ENG-SF21026-R3-FDR.pdf Markup Summary

PD-1

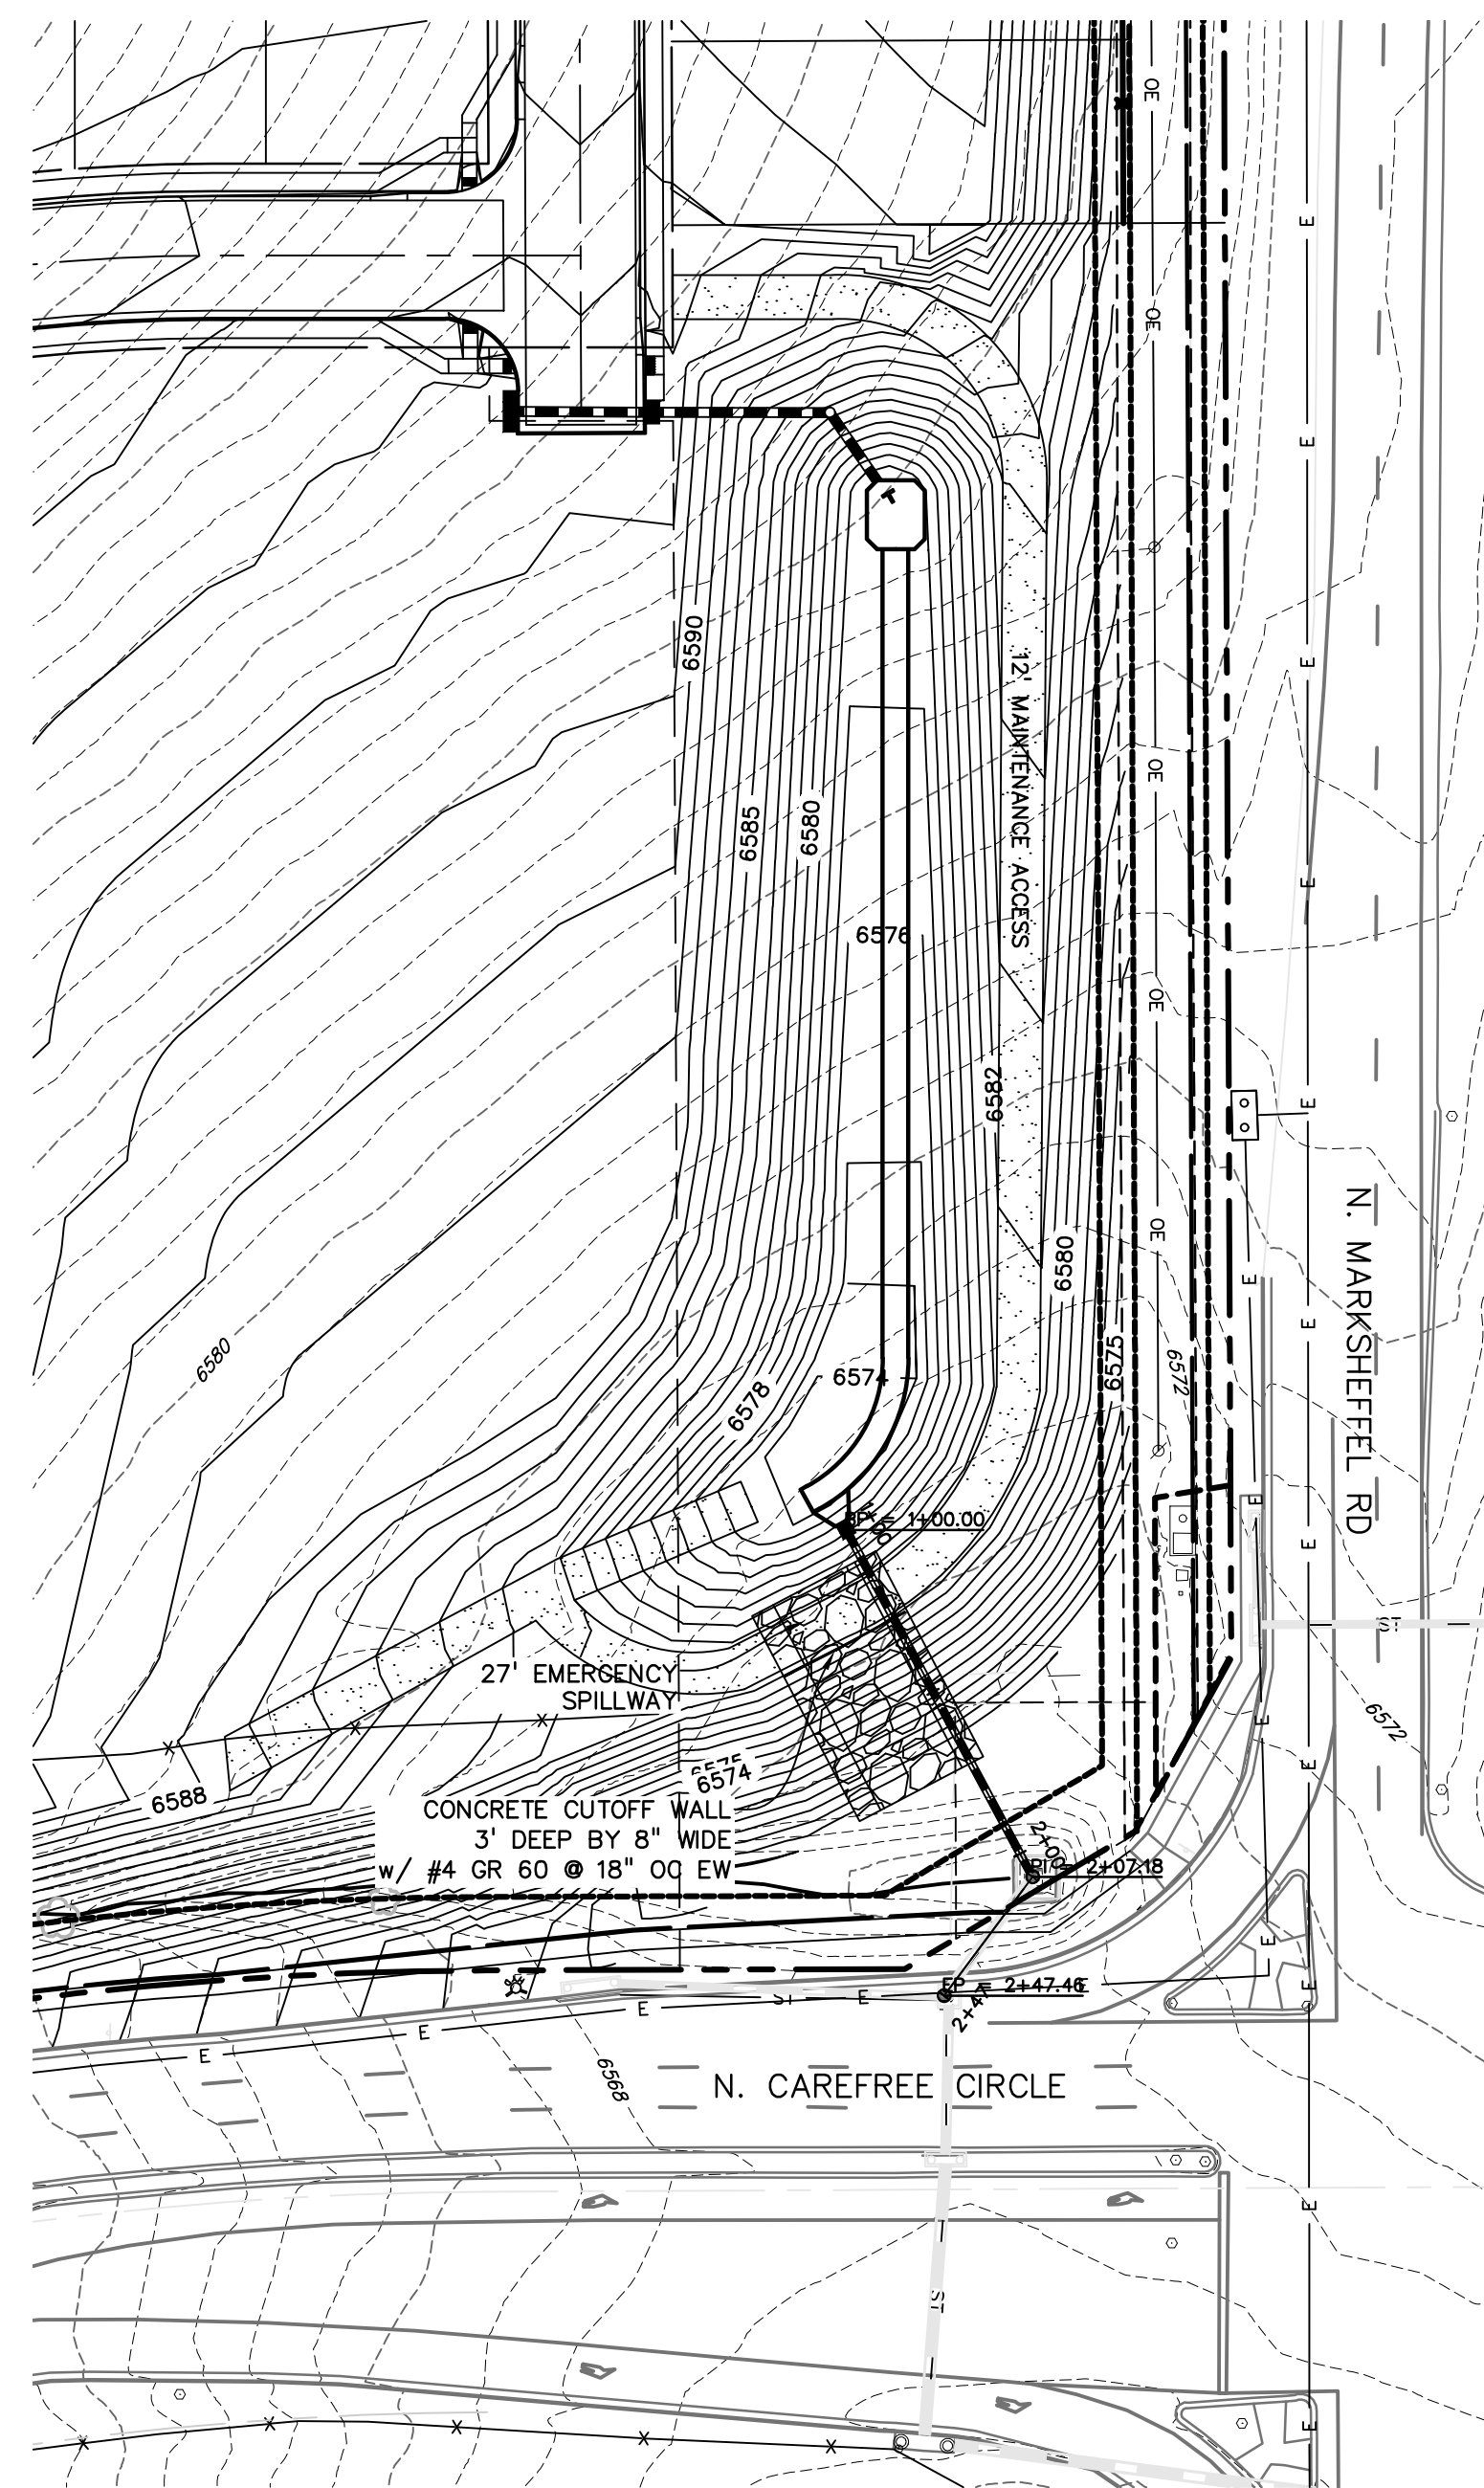
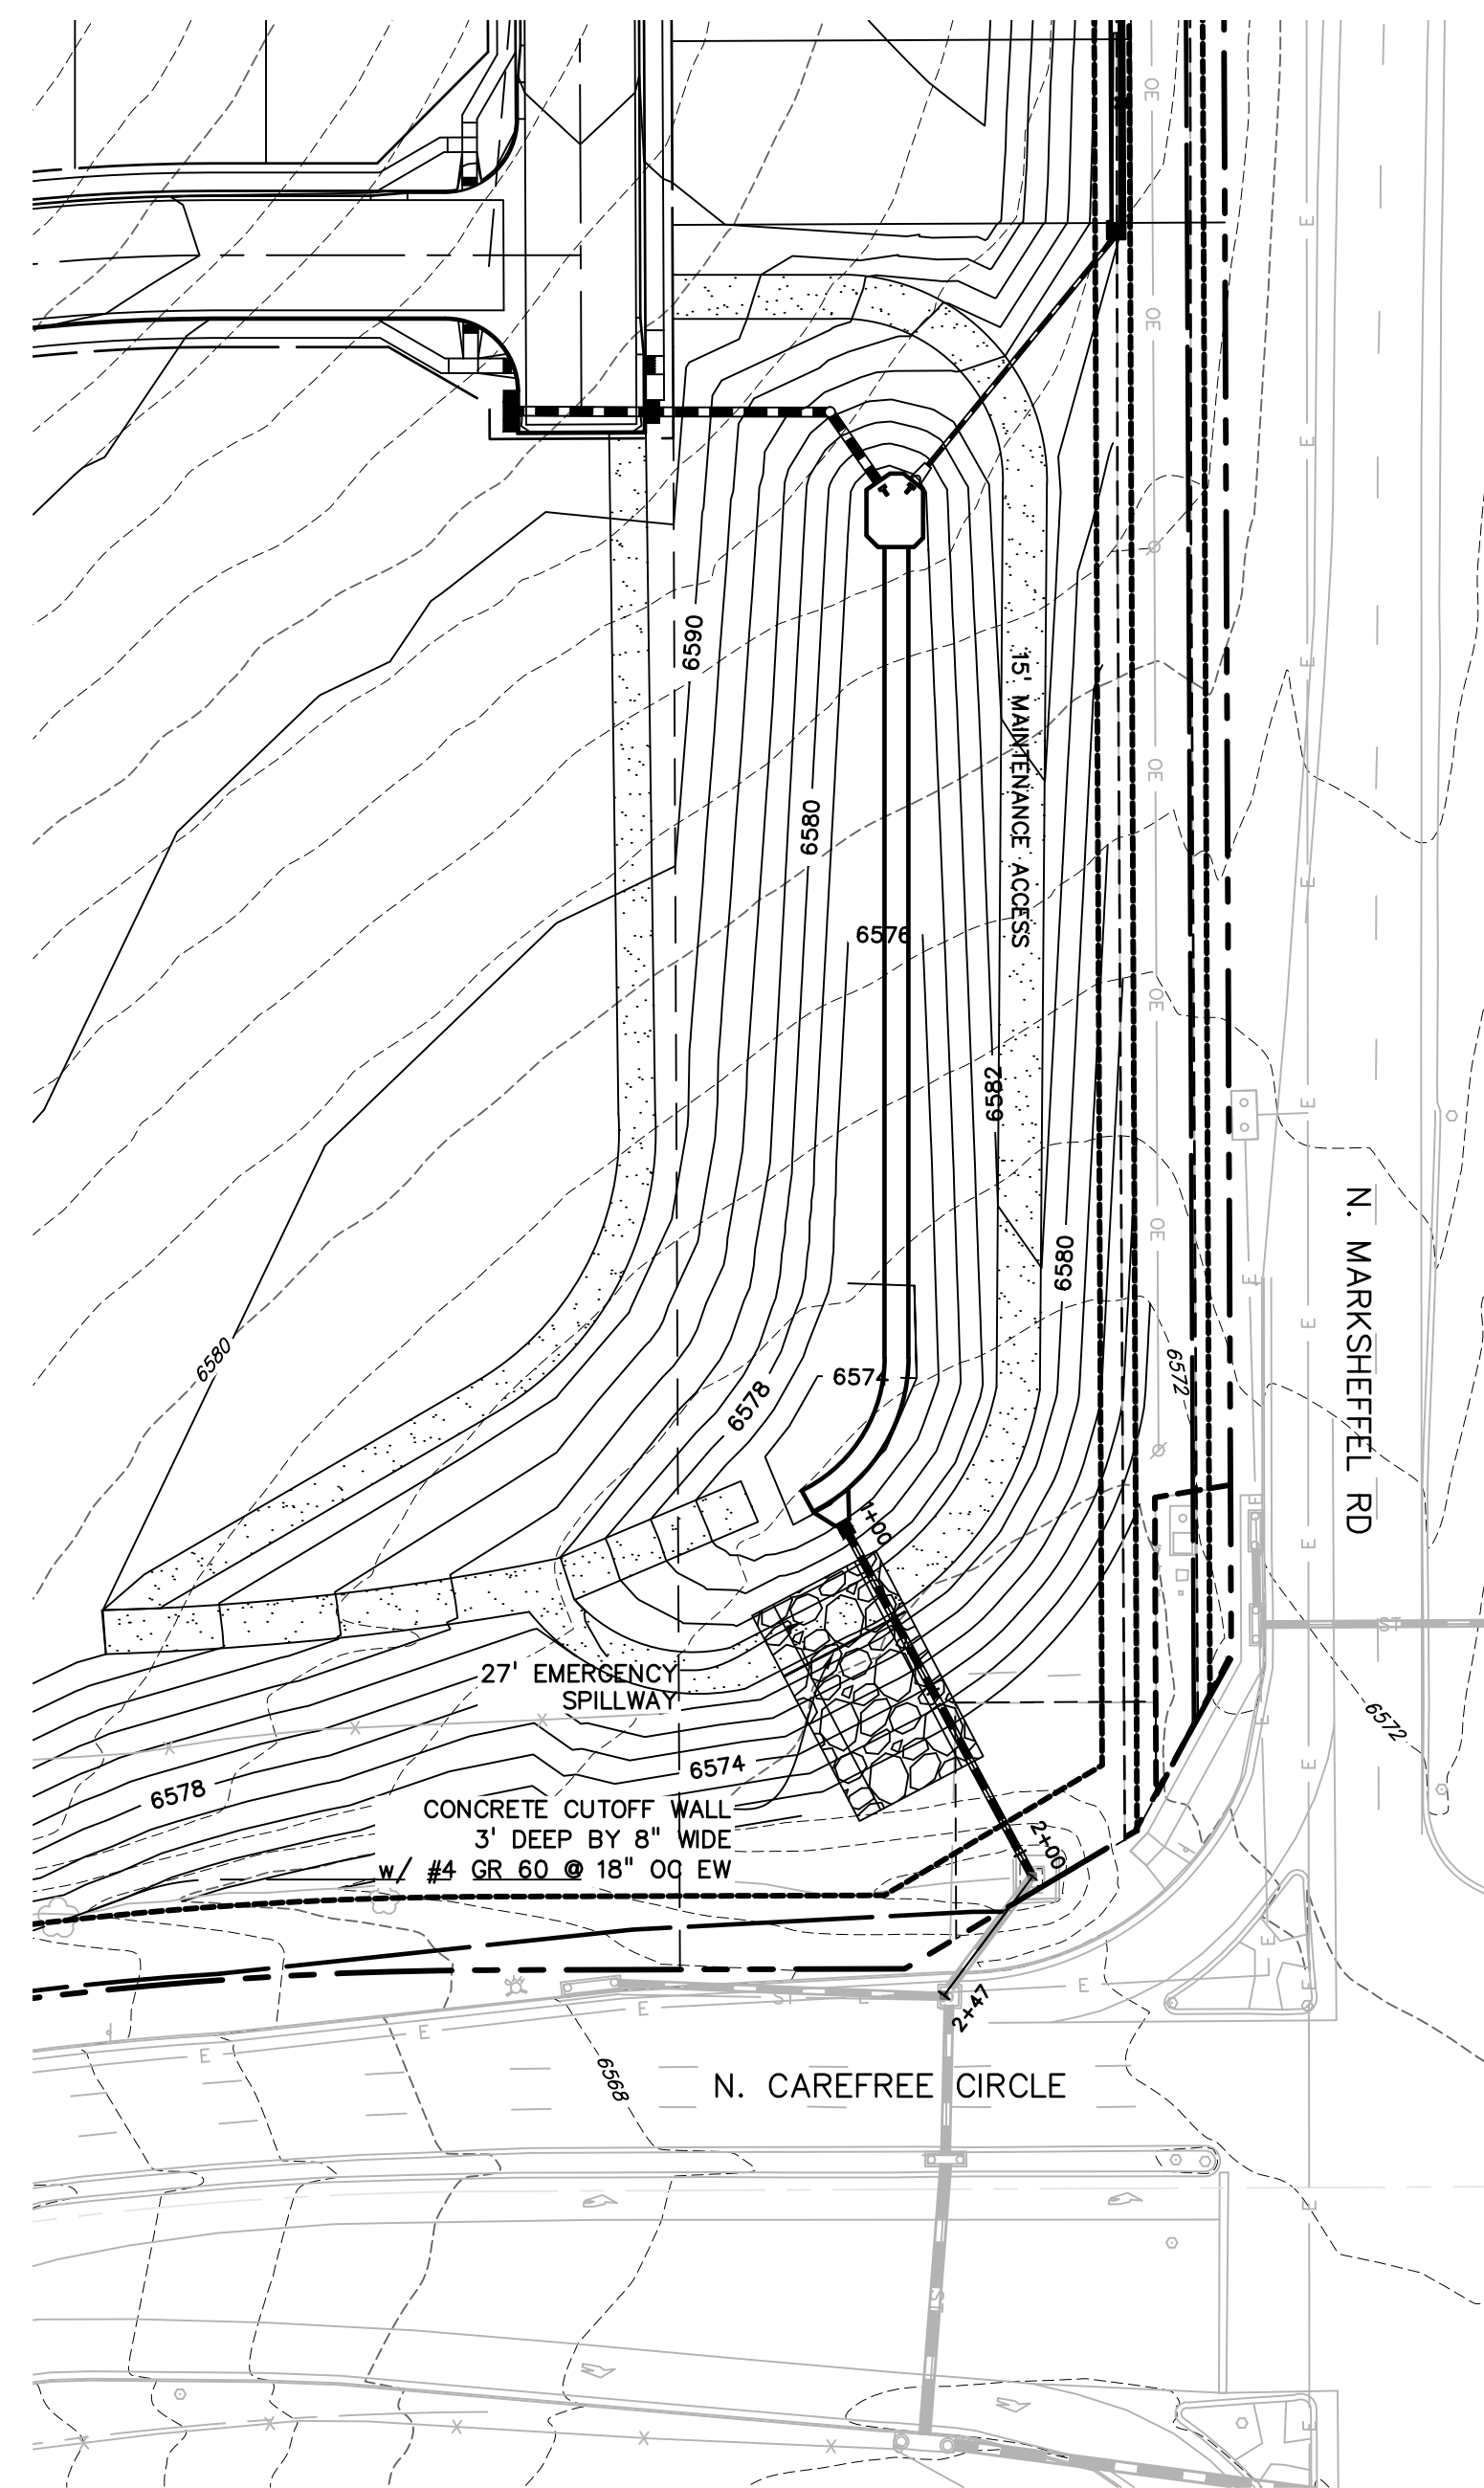
Include calculation in appendix for sizing riprap in spillway. See Ch 13 Eqn 13-9 in City DCM

Riprap sizing chart added to appendix
